Case reference: TR010056

Document reference: GWT A417 OFH1-ISH1

Gloucestershire Wildlife Trust oral representation at the A417 Open Floor Hearing one

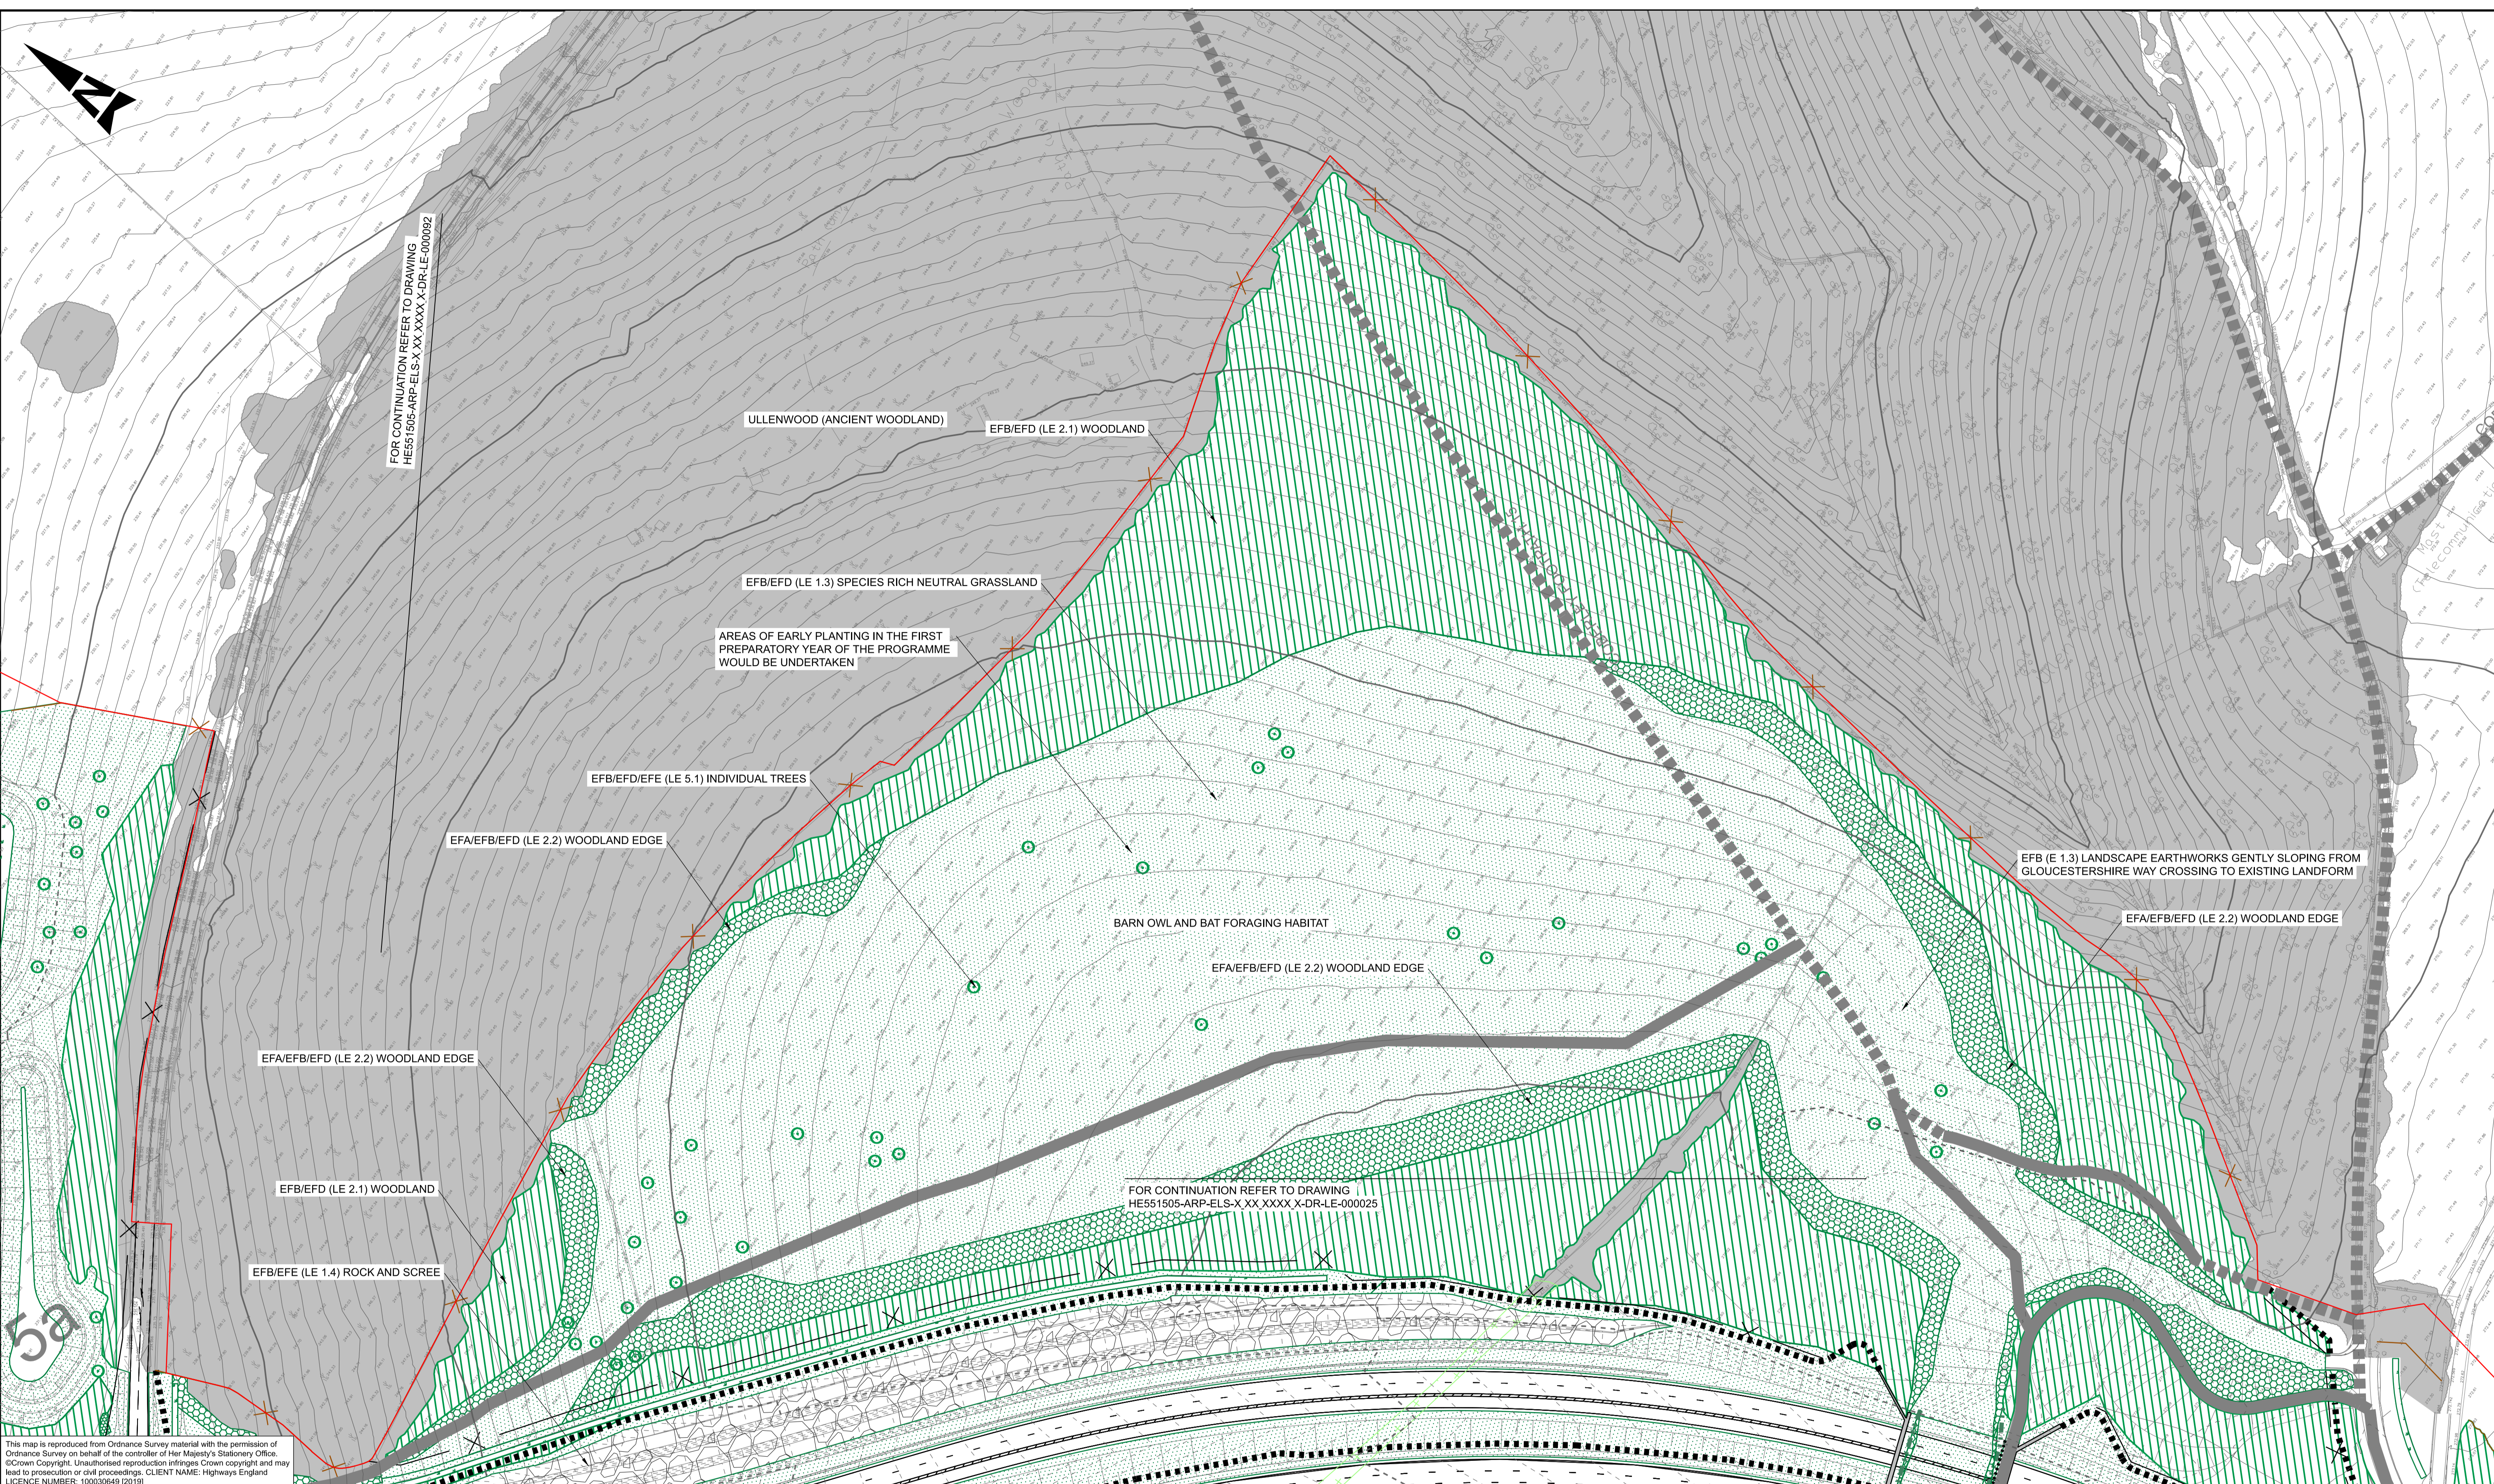
the roundabout south to create a larger buffer to reduce the negative impacts of nitrogen deposition at irreplaceable ancient woodland at the Ullenwood Local Wildlife Site, citing woodland at Emma's Grove (**DOC: 8.4 Responses to the Examining Authority's Written Questions (ExQ1)**, point 1.3.7, page 37): Emma's Grove is not ancient woodland, so it is of lesser ecological importance than the Ullenwood ancient woodland Local Wildlife Site, which should therefore be the priority ecological receptor.

- 3.2.1. The detailed mechanisms for triggering, funding, and delivering biodiversity remediation works should be secured through the DCO process.
- 3.2.2. GWT also recommends that increasing the buffer to the Ullenwood LWS should be prioritised over protecting ecological features at Emma's Grove.
- 3.2.3. Suitable new accessible greenspace is sought to mitigate increased recreational pressure on the Crickley Hill and Barrow Wake SSSI, and the Cotswold Beechwoods SAC if applicable.

- 4.5. GWT disagrees with that the applicant's position that increased NoX level on part of the Ullenwood Ancient Woodland does not represent destruction of irreplaceable habitat and that mitigation is sufficient.

- 4.6. The Trust requests that a map is provided showing the extent of the buffer around the Ullenwood Ancient Woodland Local Wildlife Site and where this falls beneath 15m.
- 4.7. The Trust requests a graphical representation of the forecast NoX levels within the affected area of Ullenwood Ancient Woodland Local Wildlife Site over the operational period of the road scheme. This will allow a better assessment of the adverse impact on ancient woodland features and mitigation provided by the transition to electric vehicles.
